RE: **U-Haul at West Bluff**
Atrisco Drive NW
Grading Plan (Stamp Date 1/30/17) and Drainage Report (Stamp Date 12/5/16)
Hydrology File: H11D059

Based upon the information provided in your submittal received on 2/1/17, the Grading Plan and Drainage Report are approved for Building Permit and Grading Permit.

RE: U-Haul at West Bluff Grading & Drainage (File: H11D059)

Please find the following responses addressing staff comments from correspondence dated January 17, 2017 listed below:

0.87' WATER BLOCK

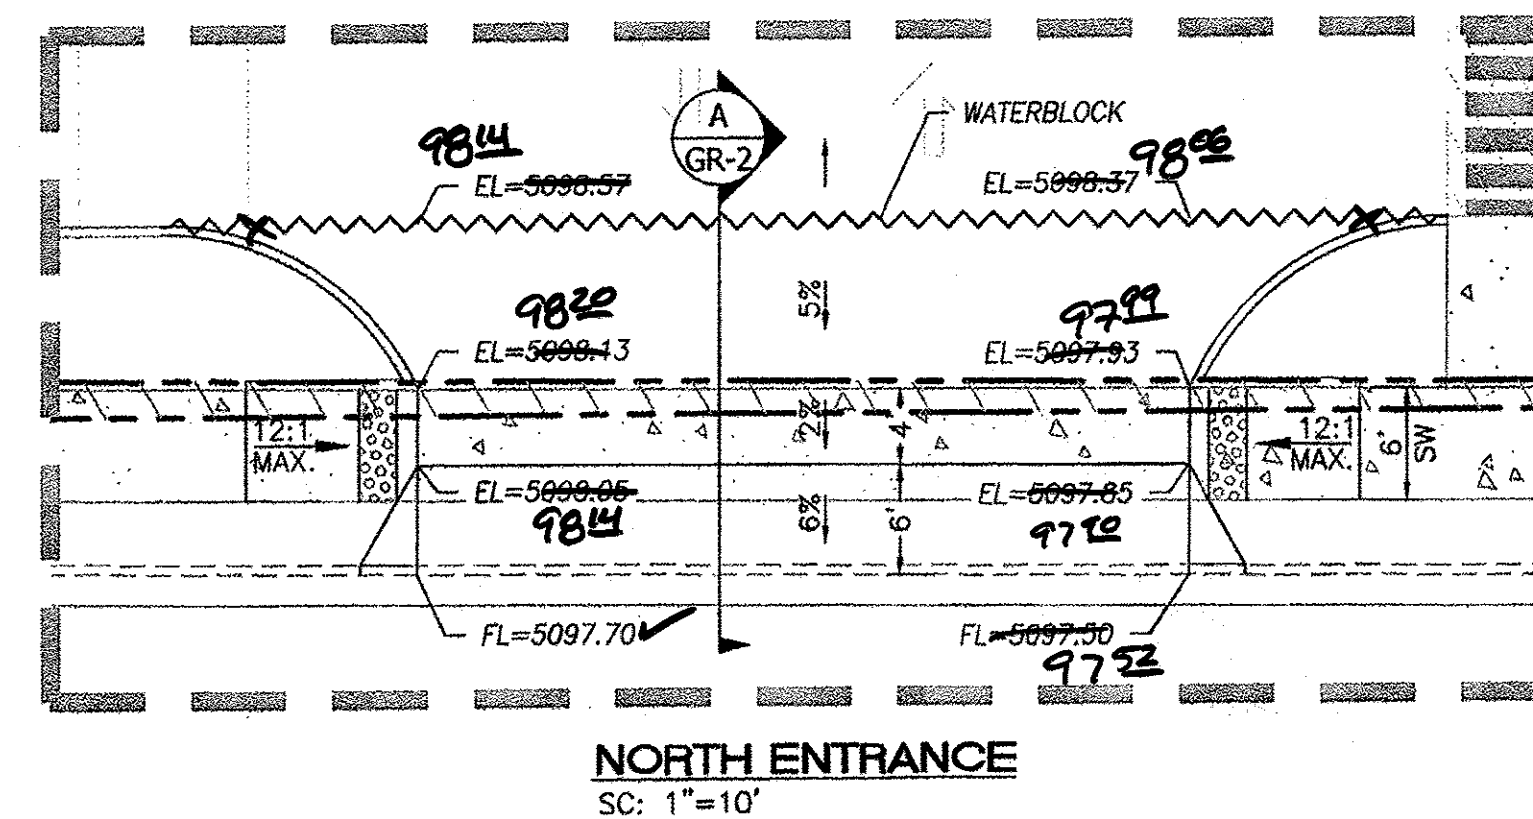
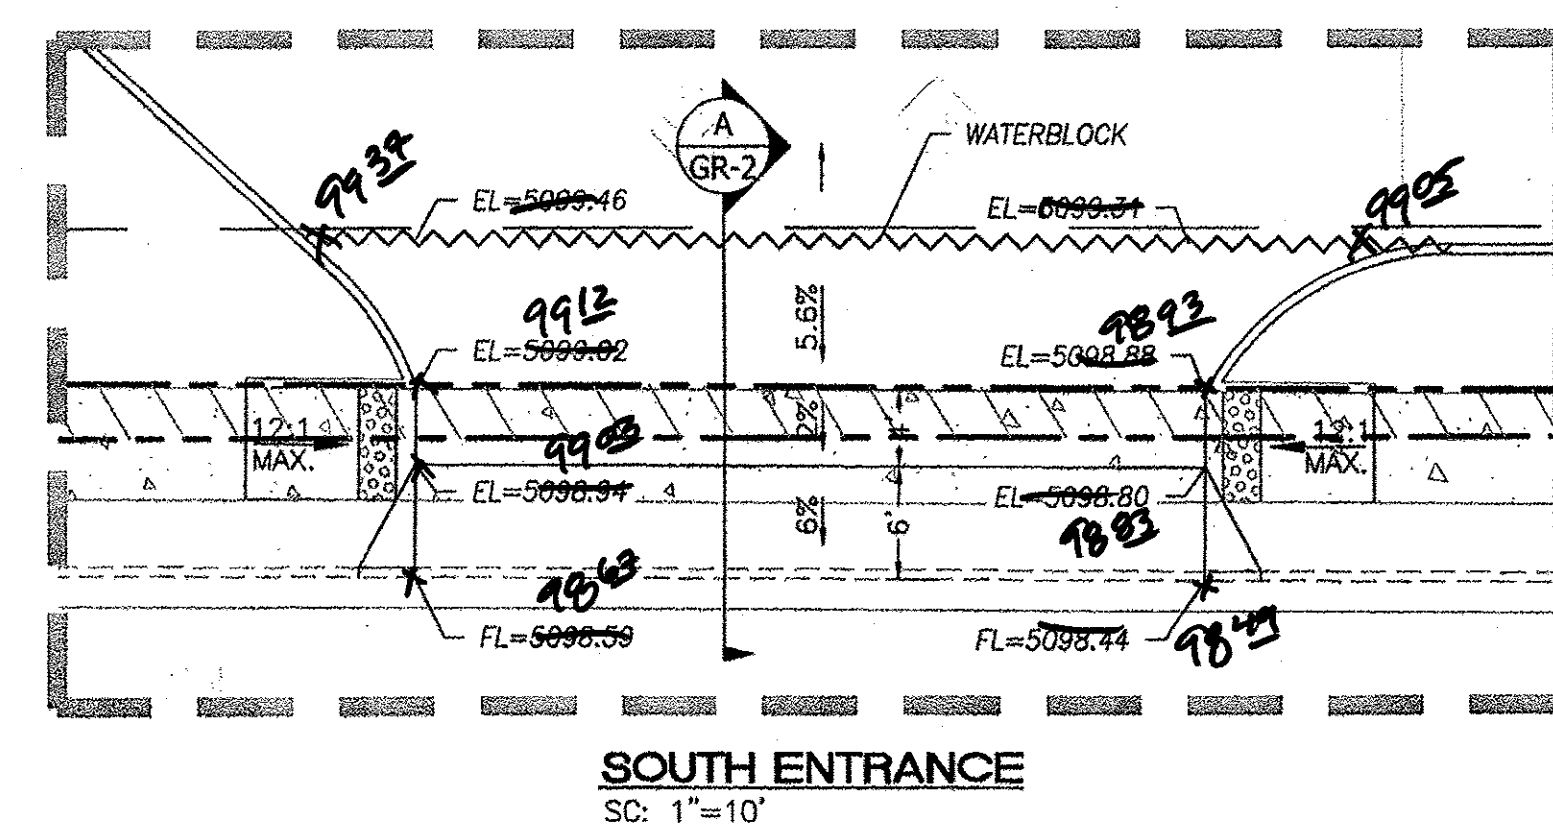
1. The North detention pond appears to be bounded by a CMU retaining wall as high as 8 feet in some places. This will need to be enclosed with a fence at least 42 inches high.

2. Call out Class IV RCP for the north detention pond outfall pipe under the retaining wall.

4. Project Benchmark and Vertical Datum is missing from the sheets. The Drainage Management Plan addresses the NGVD29 to NAVD88 shift, but sheets need this information as well.

Response: We have updated the plan (Sheet GR-1) to include a pedestrian barrier/fence.

Response: We have revised the plan (Sheet GR-1) to specify Class IV RCP for this section of pipe.

Response: We have updated the plan (Sheet GR-1) with a benchmark elevation in NAVD88.
